CITY OF ALBUQUERQUE PLANNING DEPARTMENT June 22, 2005 DRB Comments

PROJECT # 1004266

APPLICATION # 05-01017

RE: Lot 29, Alameda Business Park/spbp

**LOT 29, ALAMEDA BUSINESS PARK
SITE PLAN**

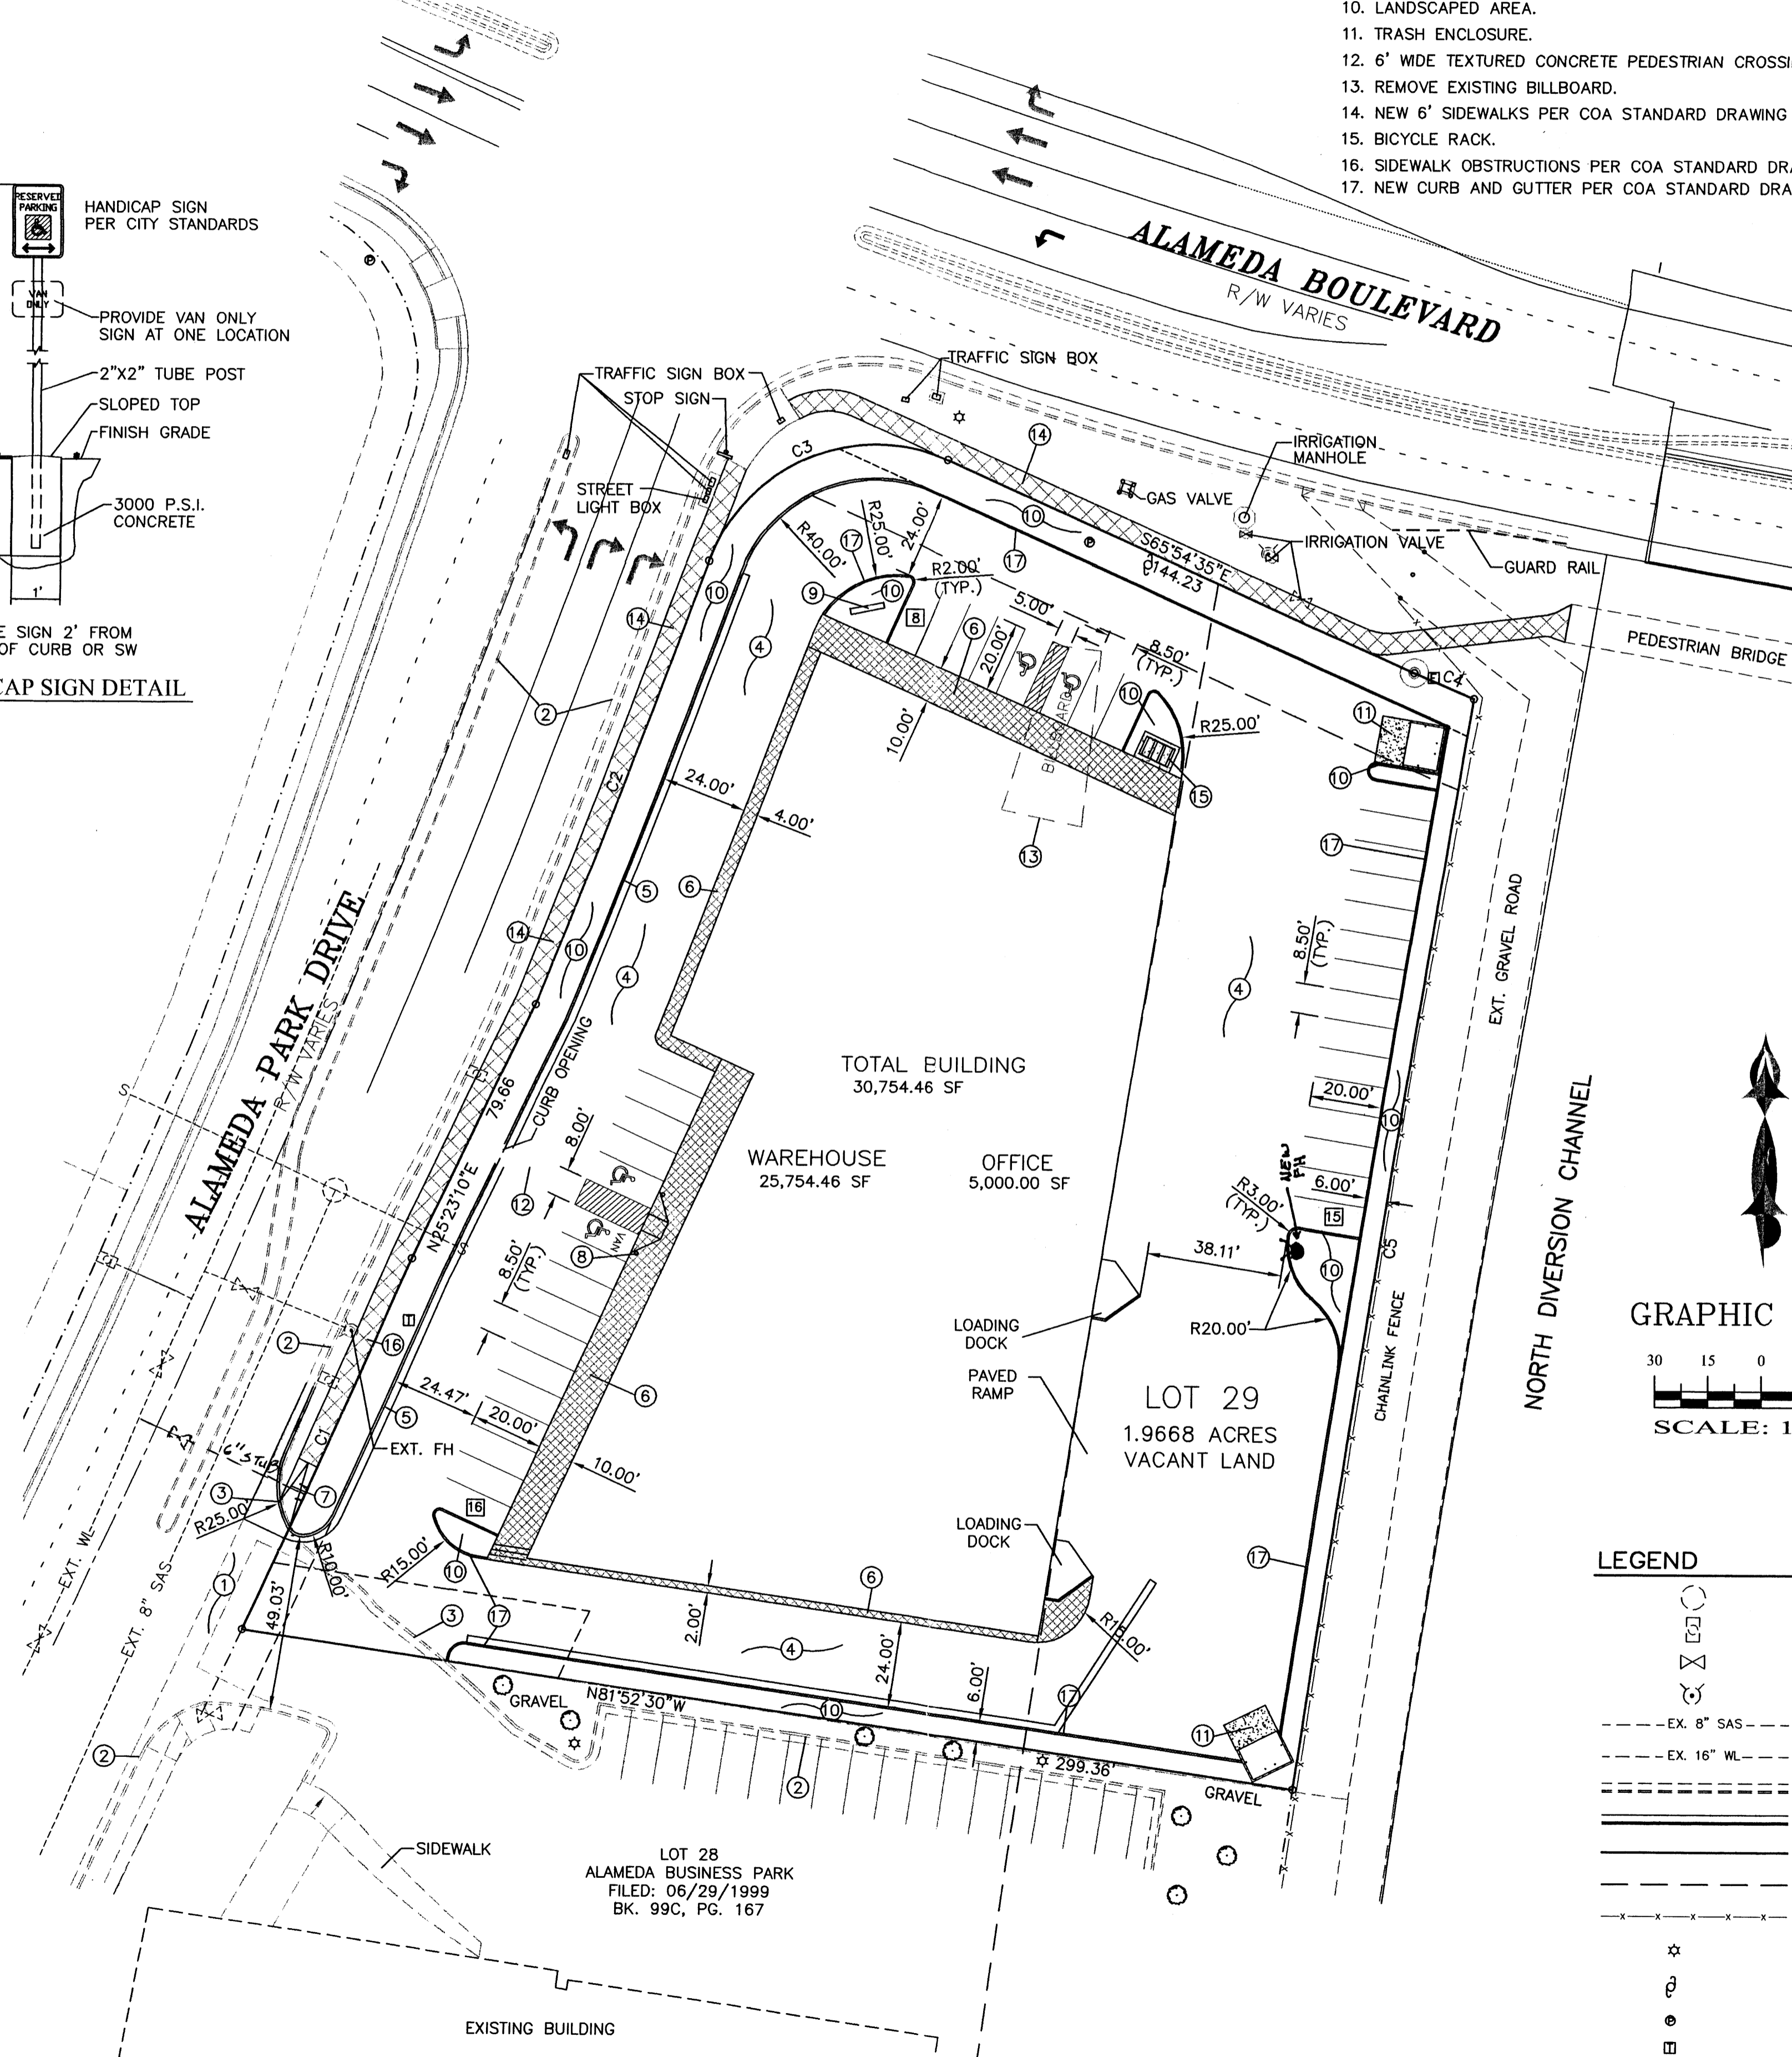
The existing & proposed easements must be shown on the Landscape Plan as well as the site plan per the SPBP Checklist.

Walls, fences and screening: checked on the Checklist. Only a chain link fence along the diversion channel is indicated on the Site Plan. Is this existing? Are there other walls or fences?

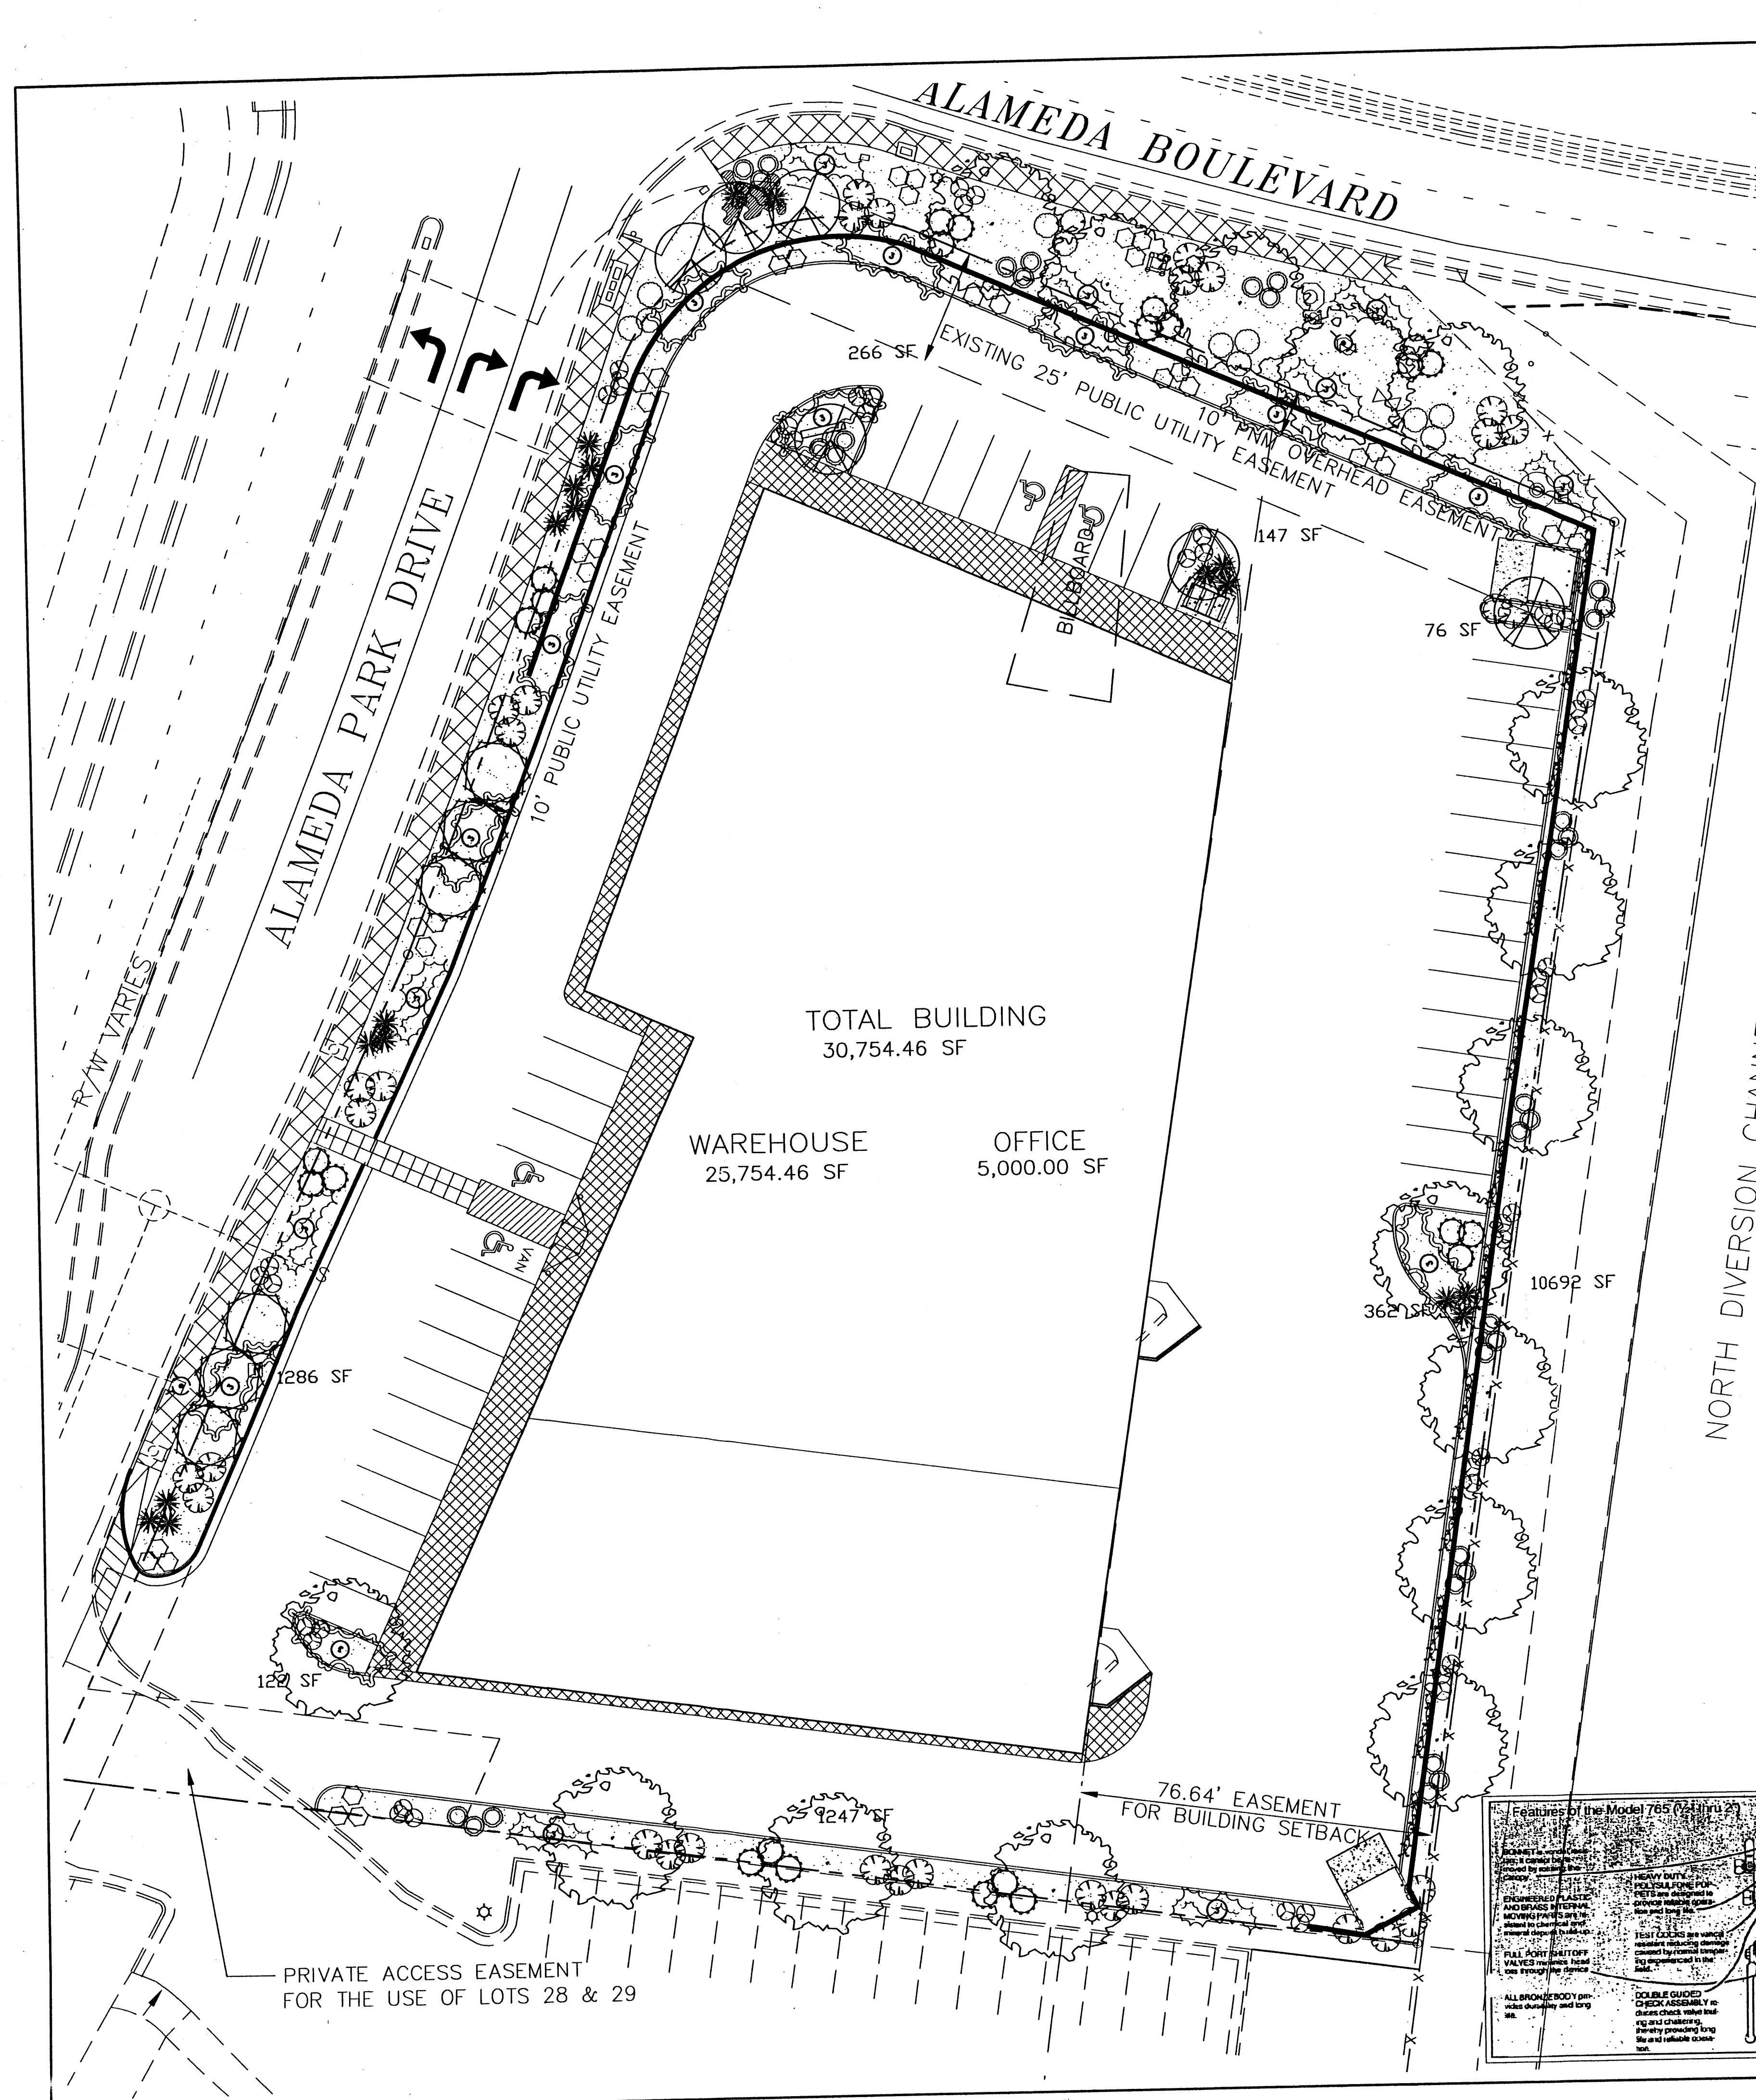
The North I25 Sector Plan & Alameda BPMP requires trees no farther than 50 feet from a parking space. Please add trees to comply with this requirement.
